CITY OF ALBUQUERQUE

November 11, 2011

**Re: Volcano Heights Drainage Compilation Report, Engineer's Stamp
Dated 10-24-2011 (C10/D000)**

Based upon the information provided in your submittal received 10-25-11, the above referenced report is approved based on the following comments:

PERFORMANCE SPEC FOR THE CHAMISA/UNSER DETENTION BASINS

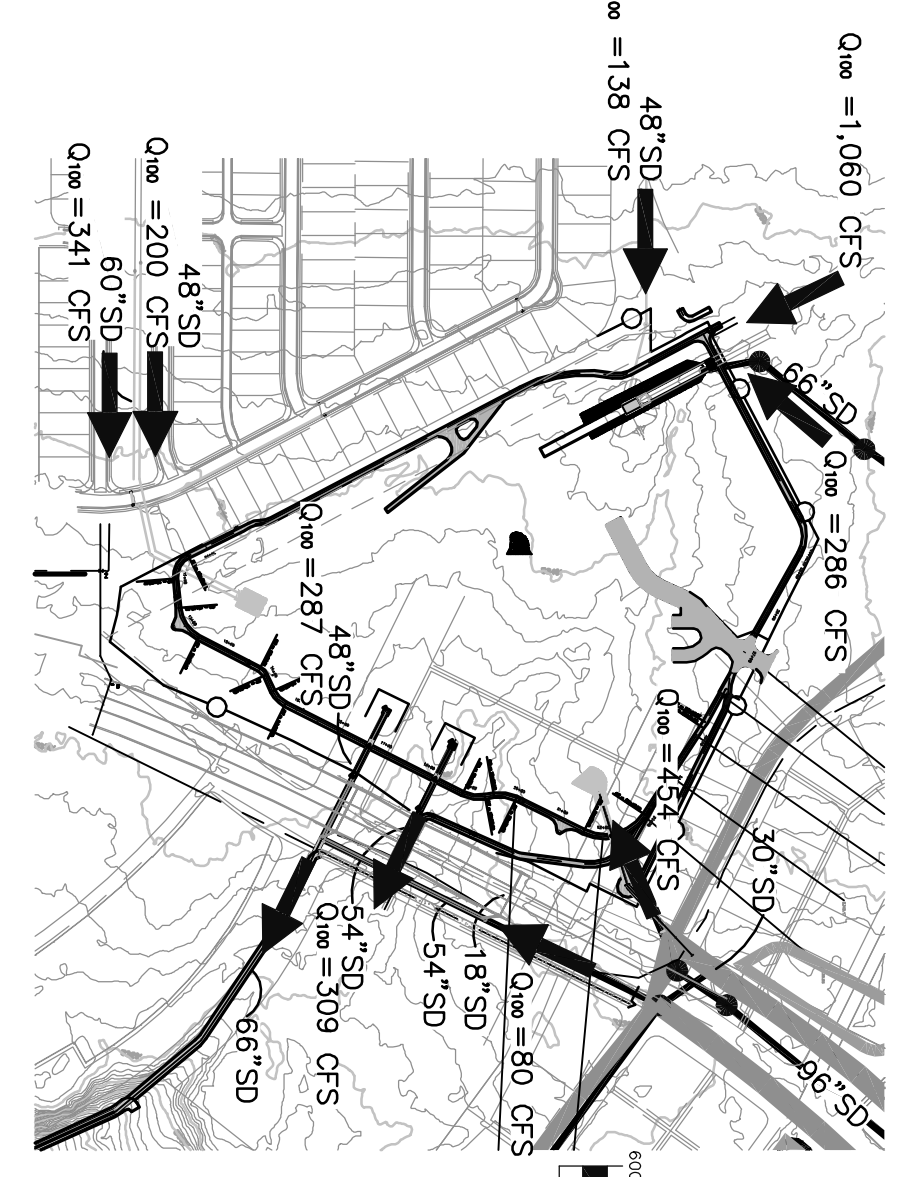
| NM 87103 | • Provide design and details for any discharge to the Petroglyph National Monument to minimize erosion. |
